From: Amanda Scholes on behalf of Planning.Responses
Sent: 28 March 2018 08:39
To: Planning Scanning
Subject: FW: Planning Consultation on EG/20/18/DOC

Comments relating to Condition 5- drainage:

EG/20/18/DOC

Description of Works: Approval of details reserved by condition imposed under EG/23/15/PL relating to conditions 3-schedule of samples & materials, 5-surface water drainage & 6-details indicating suitable provisions for bats/owls habitats.

EXISTING DRAINAGE FOR SAND SCHOOL - (1 NORTHFIELDS COTTES PO203

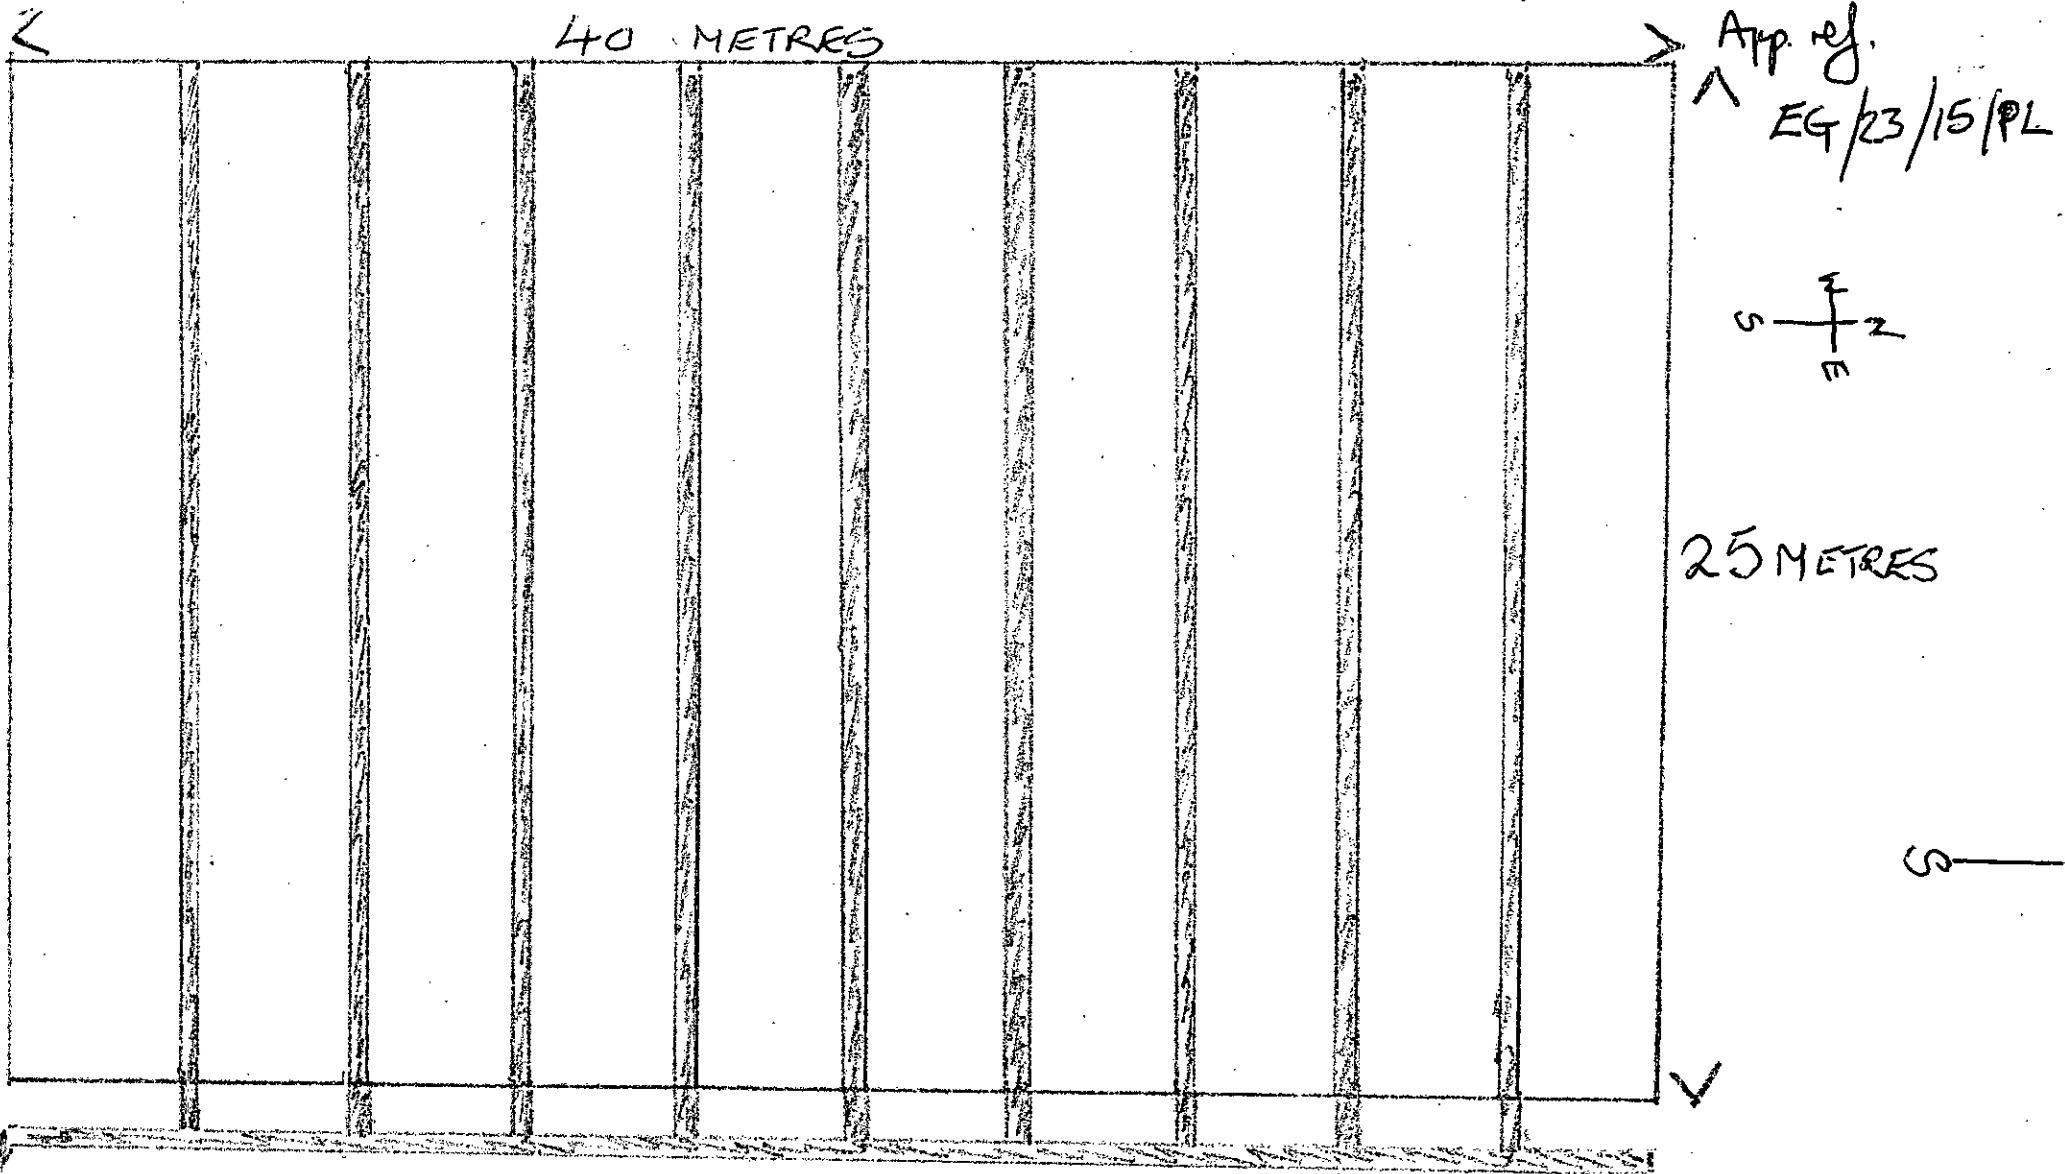
- Please provide details of the sand school and existing drainage on the layout plan as well as the location of the overflow.
- All French drains and connectivity needs to be clearly shown on the layout plan with dimensions- width, depth and length.
- All pipes need to be shown in plan, with diameters, invert levels and slopes clearly shown.
- The location of manholes needs to be added to the plan. With all levels shown.
- Silt traps will be required upstream of any French drain.
- Please provide construction details of: French drain, manholes, and silt traps.
